**Ms Jillian Rann**

Kirklees Council Planning Department

**RE: 2025/65/91645/W | Turnbridge Mills, Quay Street, Huddersfield, HD1 6QT (Grade II, 1871-3). Application for demolition and redevelopment.**

Quay Street Elevation as Proposed

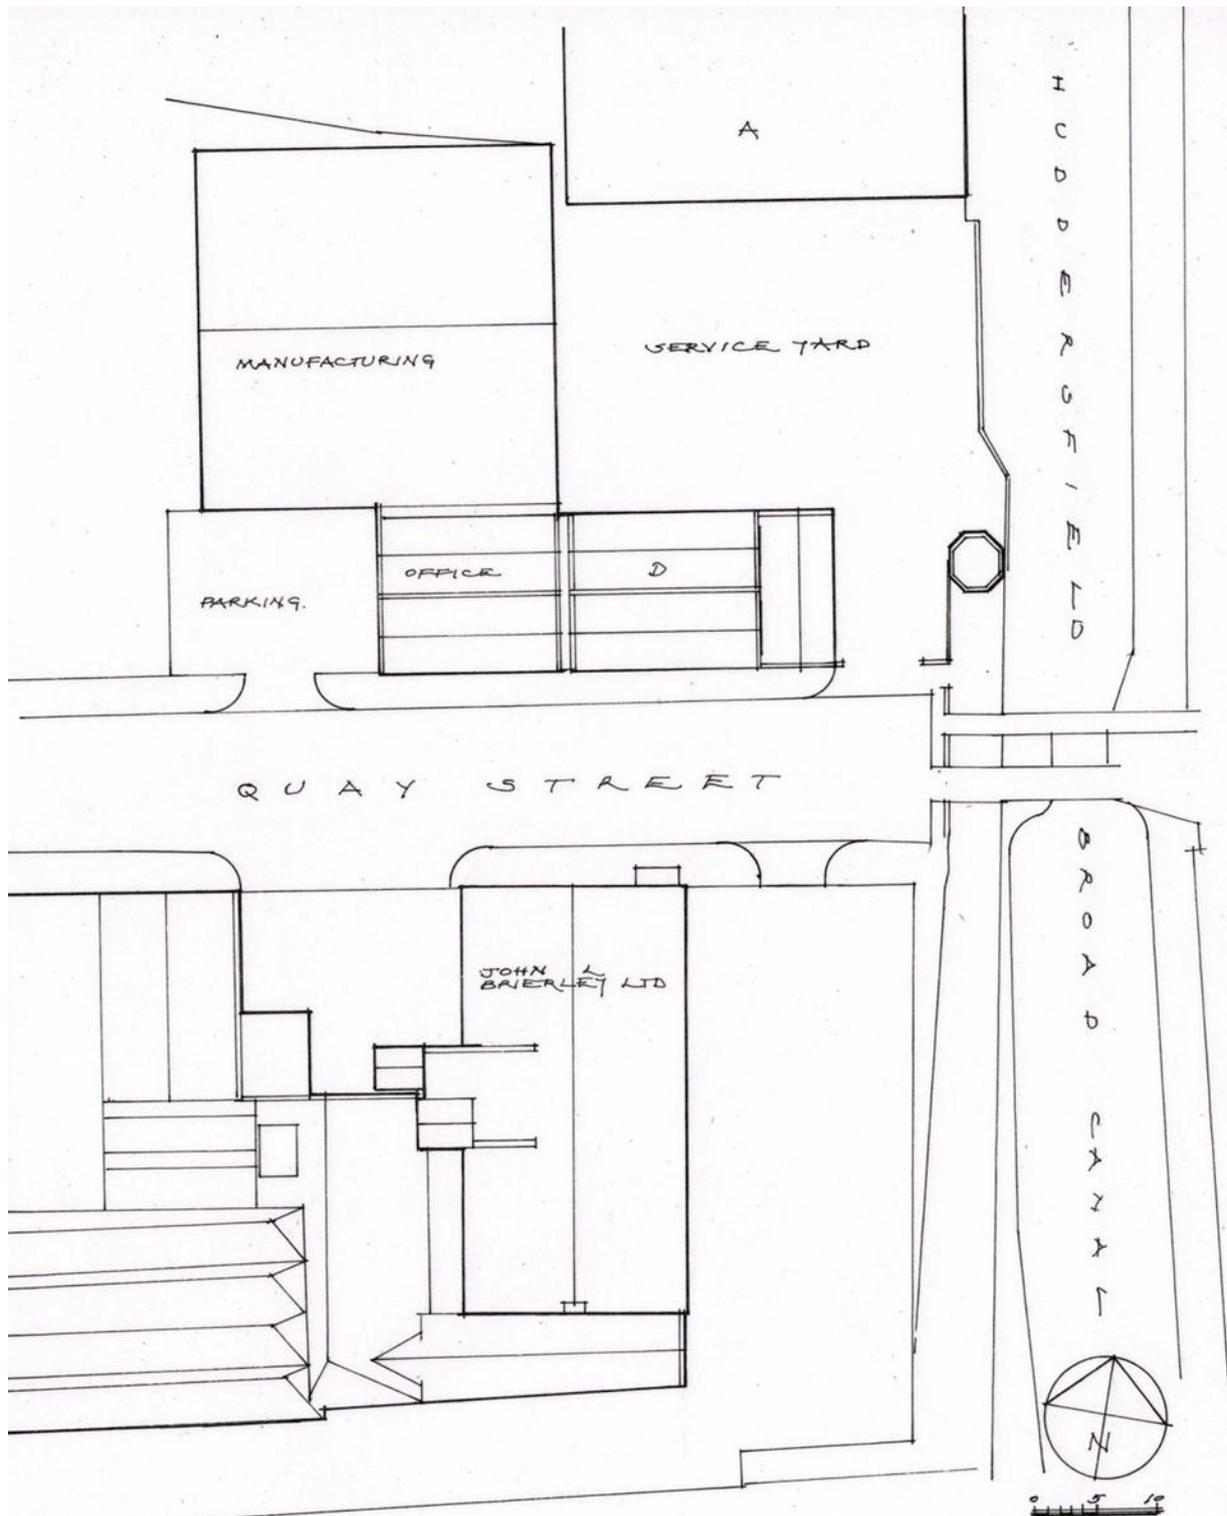
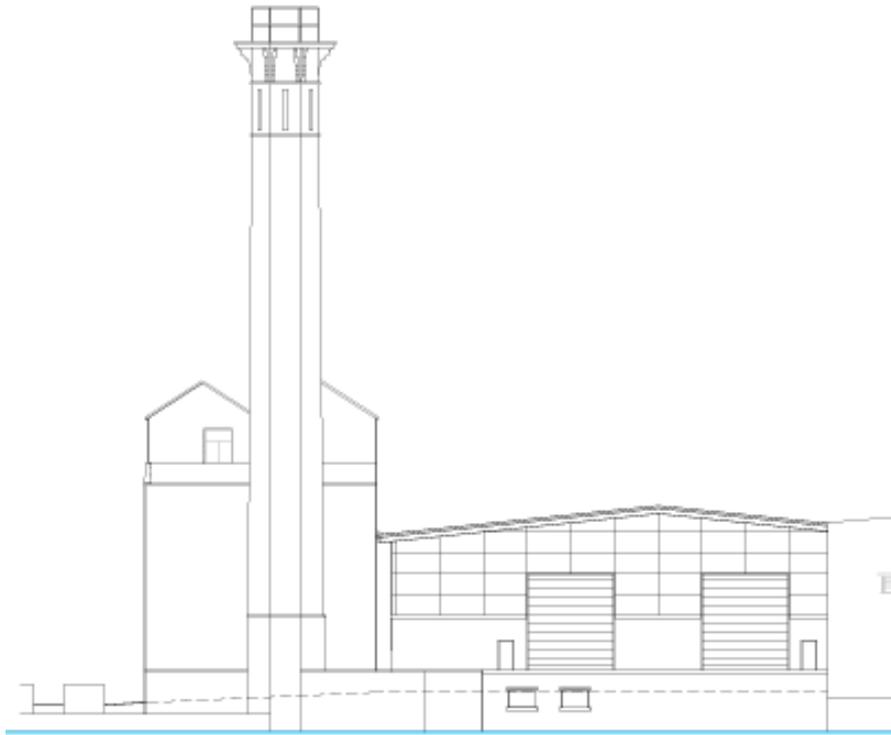
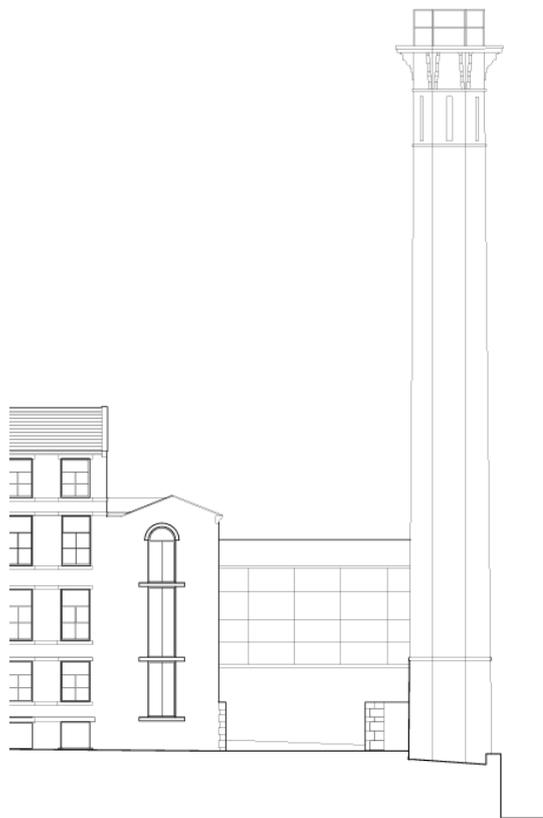
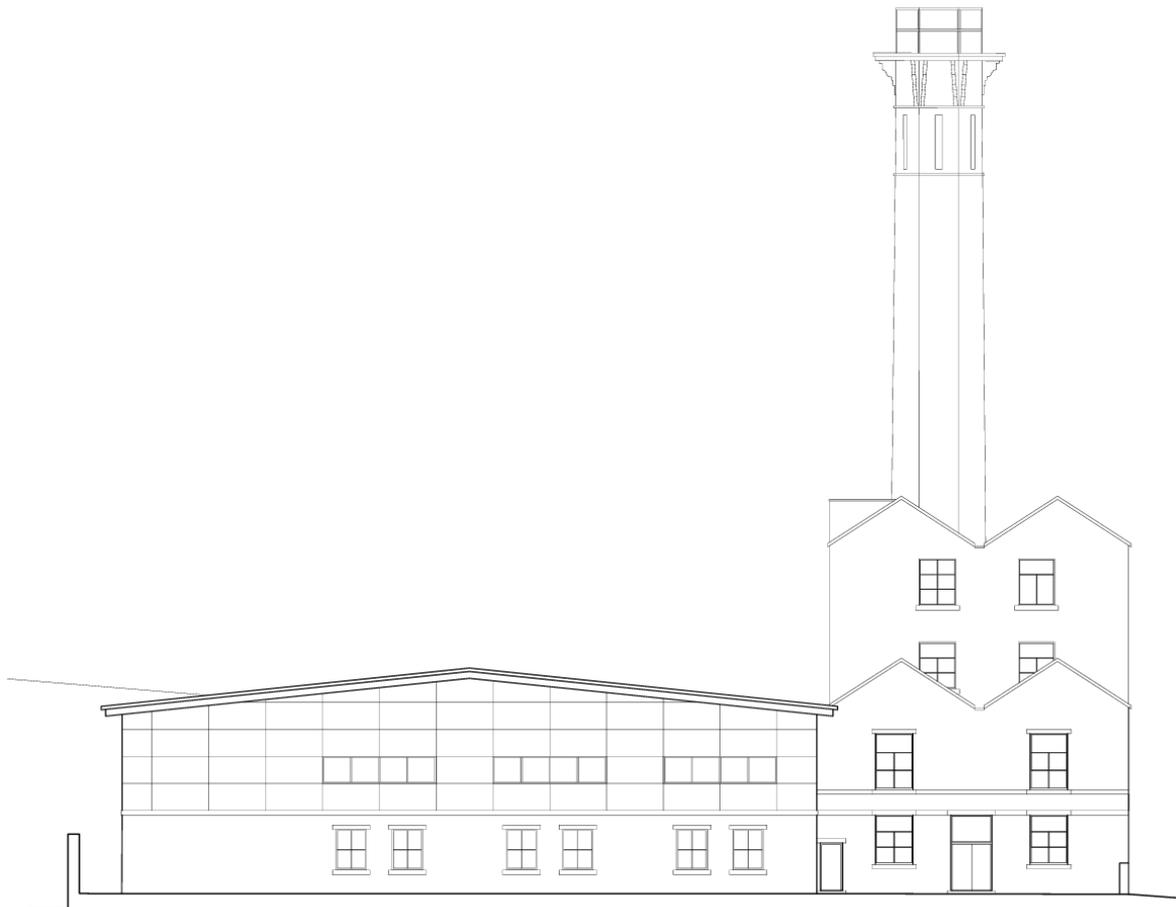
This application seeks to demolish several buildings on the site, and redevelop the area, having a harmful impact on this nationally significant collection of buildings. Its replacement does not enter a cohesive and considered dialogue with the remaining mill buildings.

We object to these plans due to this harm, and the unsympathetic language of the replacement. The existing mill complex is defined by a great verticality in its architecture, not just of the chimney but also of the mill buildings. Its proposed replacement does not reflect

this verticality and thus harms the unique character of mill architecture. While it is recognised that some of the buildings are in a state of disrepair, this is not entirely unusual for historic buildings and an experienced conservation architect should be able to navigate these challenges successfully.

It is important to note that the Victorian Society supports careful and considered adaptation of historic buildings, this scheme would irreversibly harm several listed buildings and an important streetscape for Huddersfield. A scheme which reflected the wider character of the area and sought to preserve as much historic fabric as possible would be more acceptable to the Society.
